Our Case Number: ACP-323932-25

Re: Proposed development comprising of 94 no dwelling units, Lissywollen, Westmeath
Lissywollen, County Westmeath

Uisce Éireann's Ref: PN25000035364

Uisce Éireann (UE) has reviewed the plans and particulars submitted with the application and has the following observations;

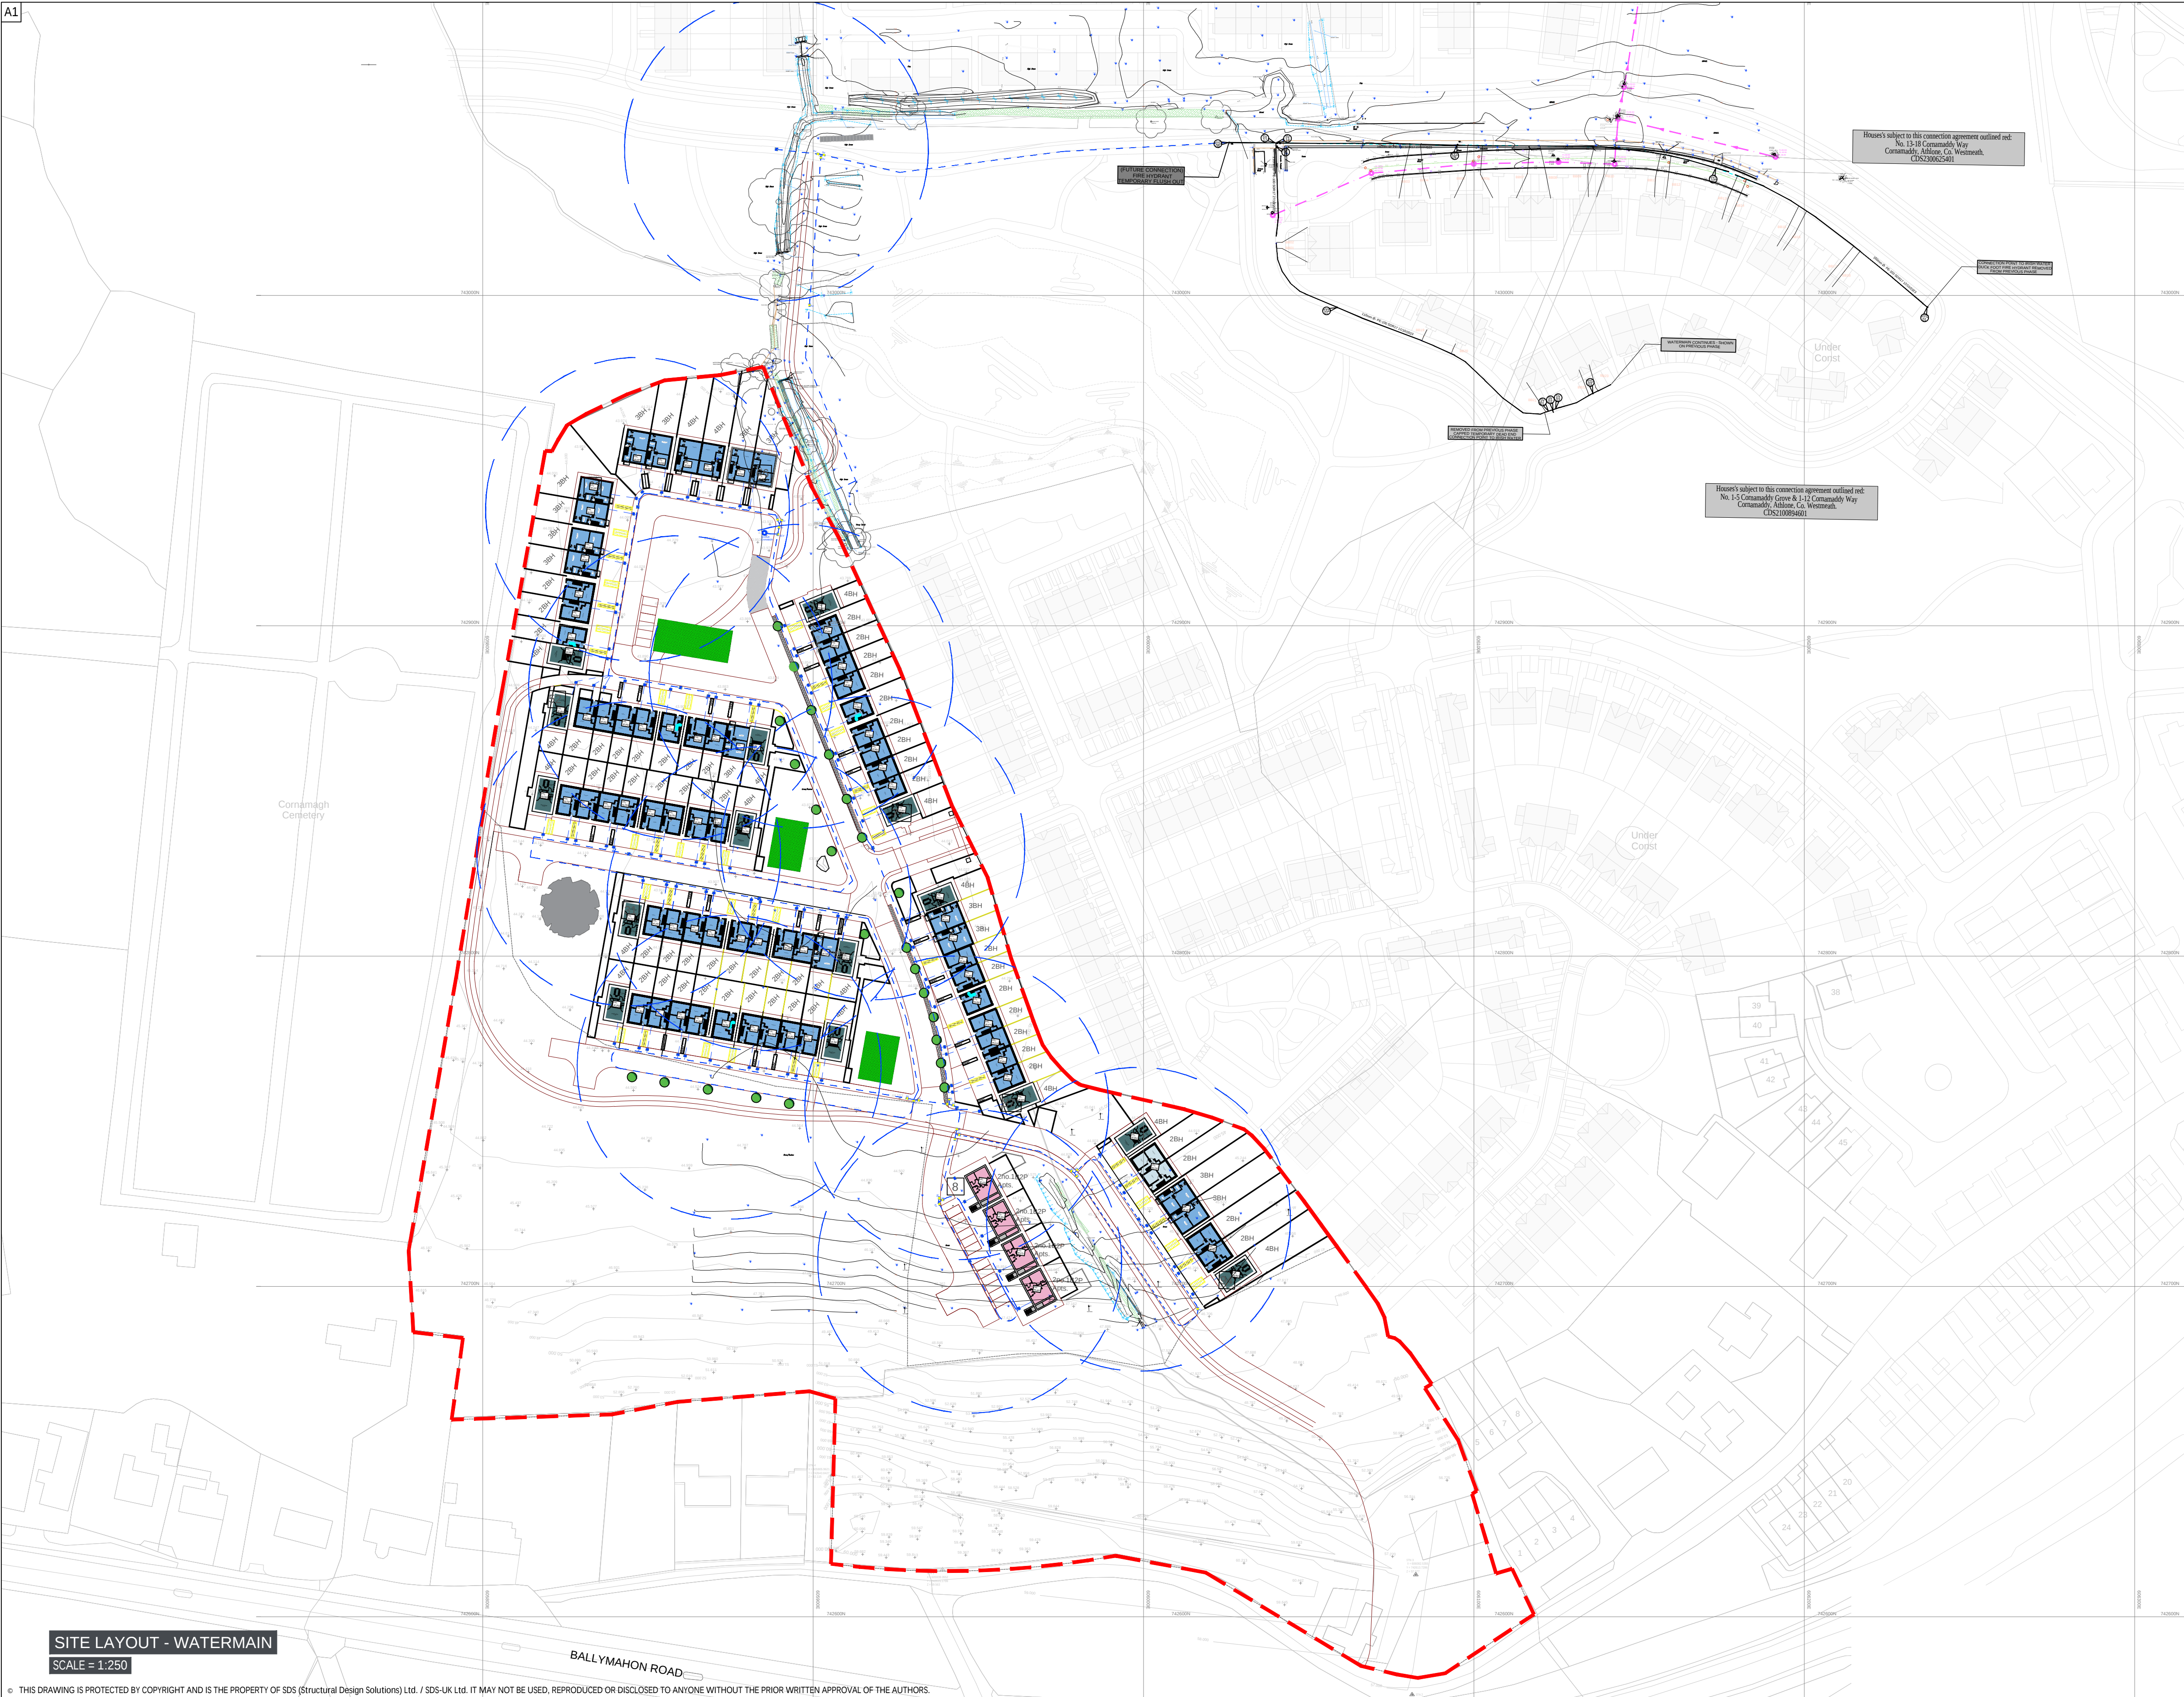
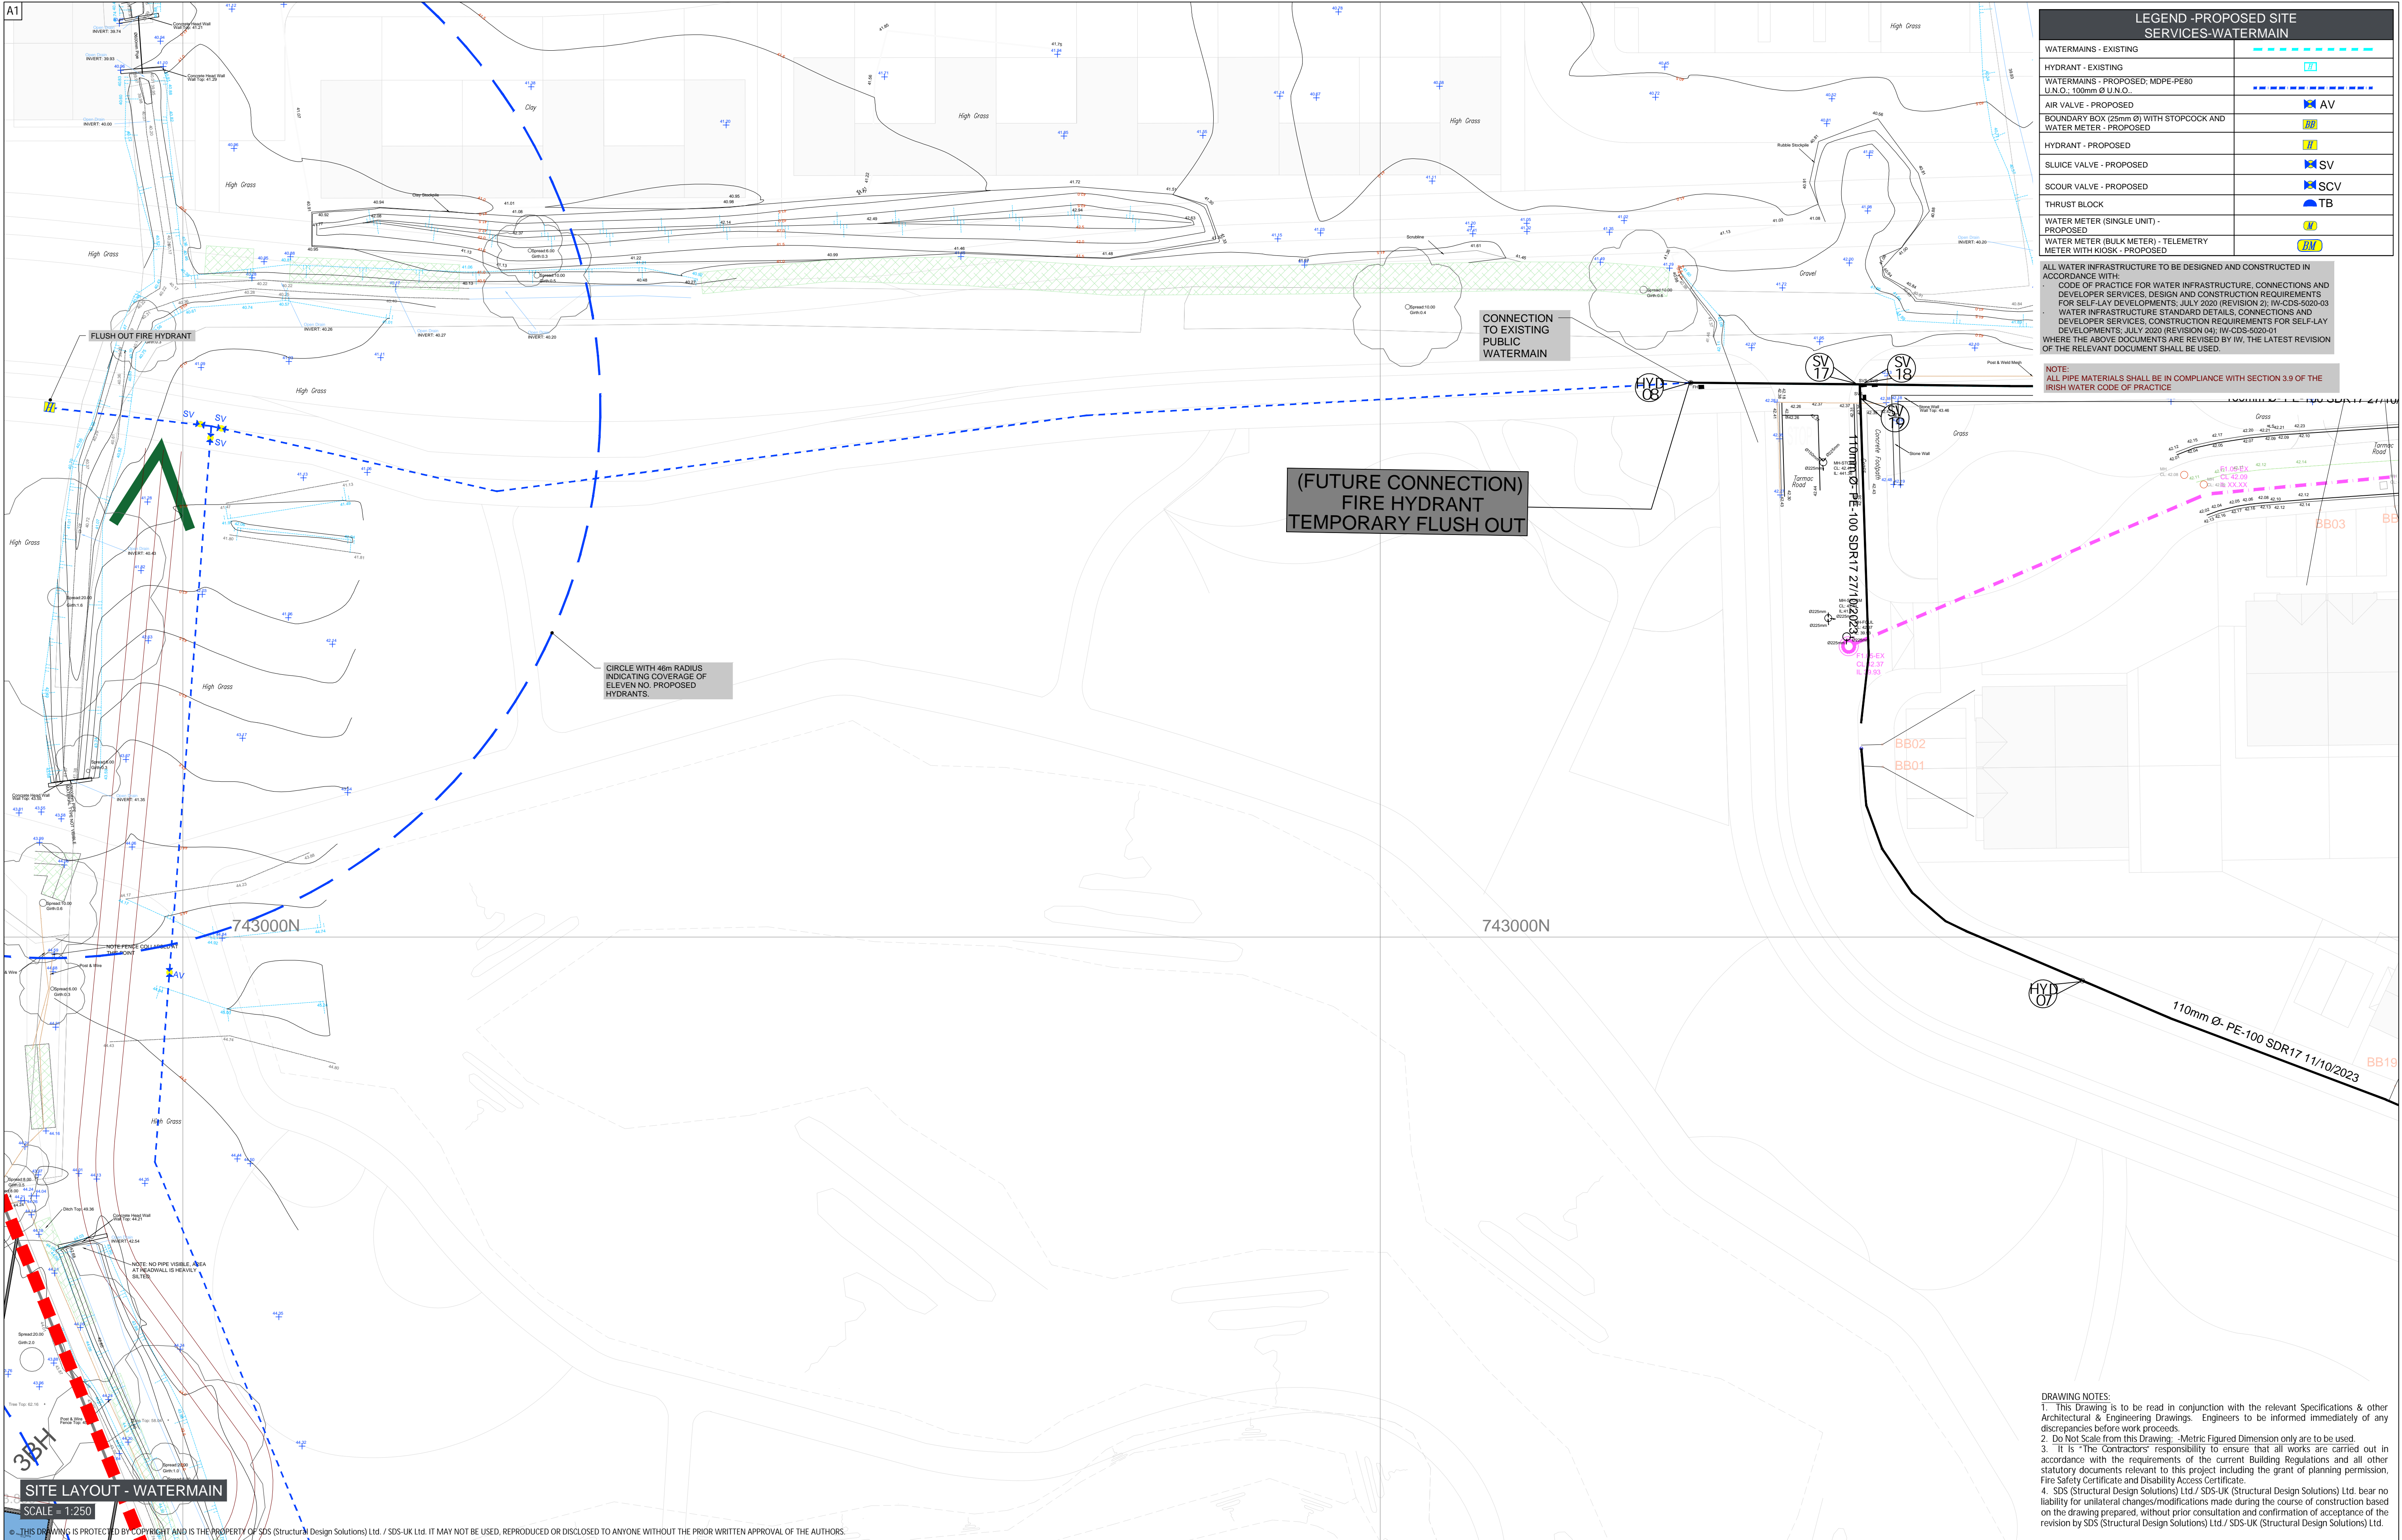
2. The applicant / developer shall fund the extension of the potable water network required to provide a connection to the proposed development - approximately 210 metres of 150mm diameter watermain - in accordance with the particulars of the Connection Agreement.
